Case Reference ABP PAX07.323761  
Administrative Officer  
An Coimisiún Pleanála  
Strategic Infrastructure Development Section,  
64-67 Marlborough Street,  
Dublin 1  
D01 V90

**RE: ACP- PAX07.323761: Proposed Development of the Wind Farm Development Project (and all associated works) at Cooloo and surrounding townlands, Co. Galway.**

This submission outlines observations from the OPW on the Strategic Infrastructure Development (SID) application by Neoen Renewables Ireland Limited to An Coimisiún Pleanála for planning permission in respect of the construction of nine wind turbines within the townlands of Cloondahamper (Blake), Cloonascragh, Elmhill, Cooloo, Lecarrow, Dangan Eighter, Lissavally and Slievegorm in Co. Galway.

Figure 14-9: National Monuments within 10km of proposed turbines.

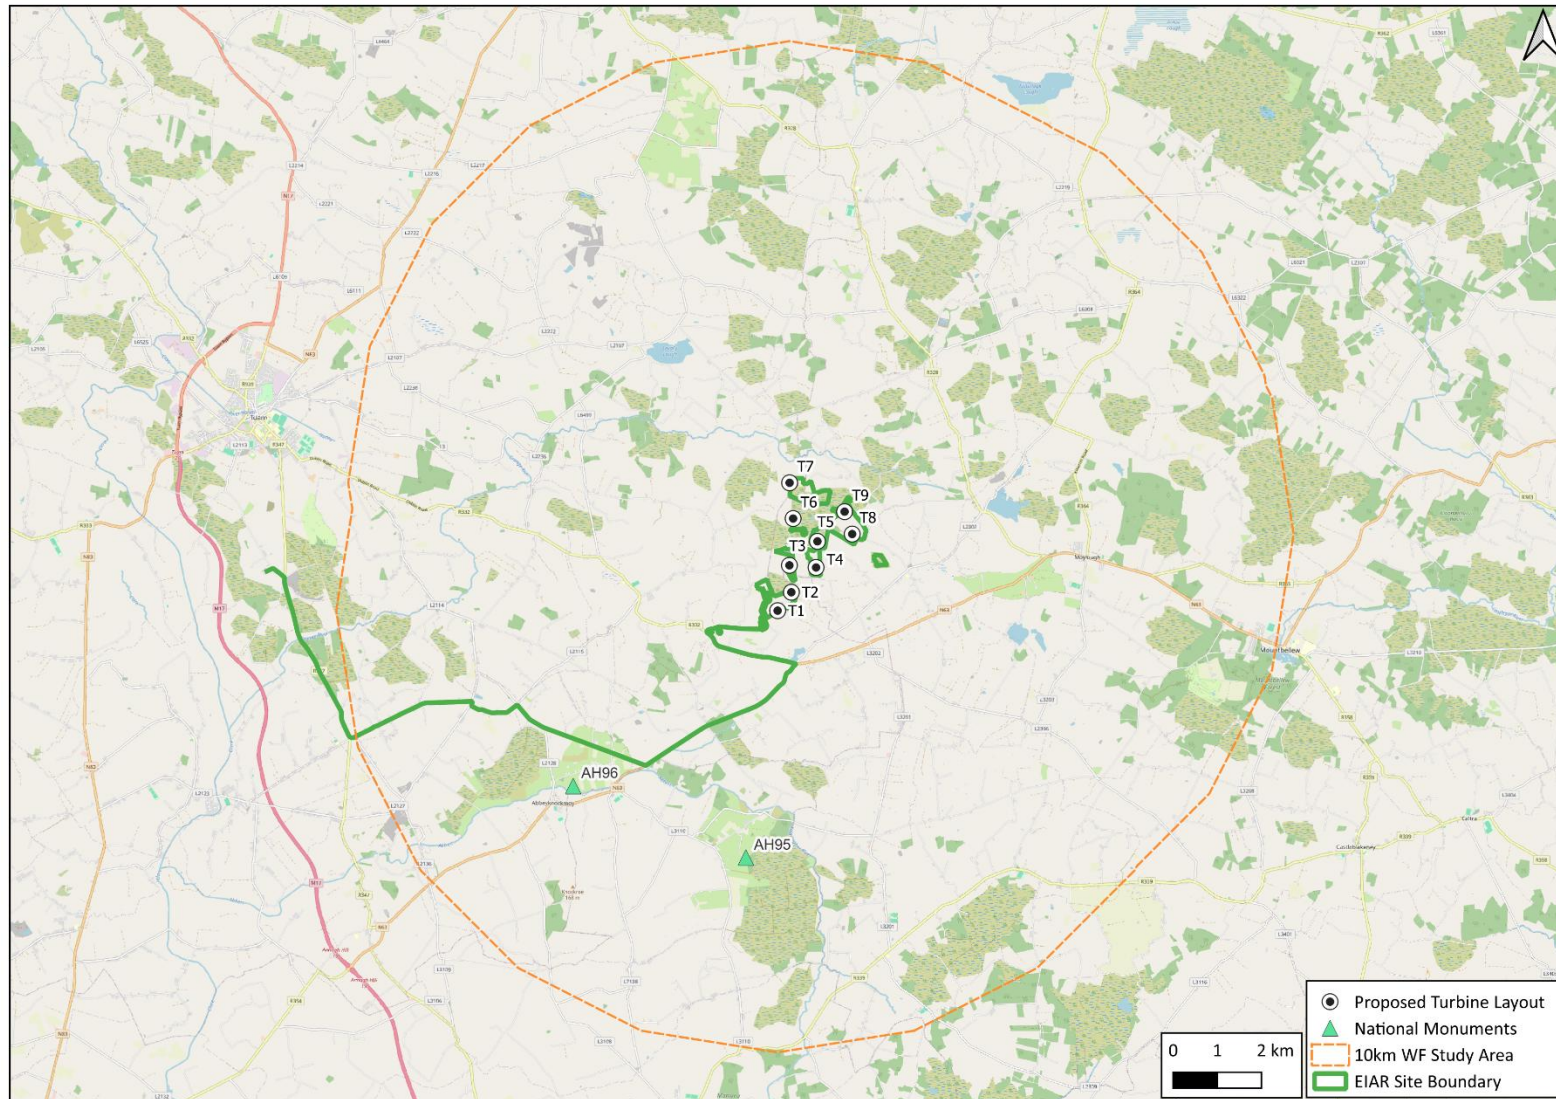
Chapters 13 and 14 make reference to some of the sites, in particular, to Knockmoy Cistercian Abbey (NM 166), from which the windfarm is visible.

It is also noted that there is a VP (viewpoint) assessment of a location on the east side of Tuam. The application documentation does not appear to provide evidence of an assessment through ZTV (Zone of Theoretical Visibility) mapping of the National Monuments in State care, or of baseline photographs from these sites looking towards the proposed Cooloo windfarm site, or broader views depicting other cumulative windfarm sites.
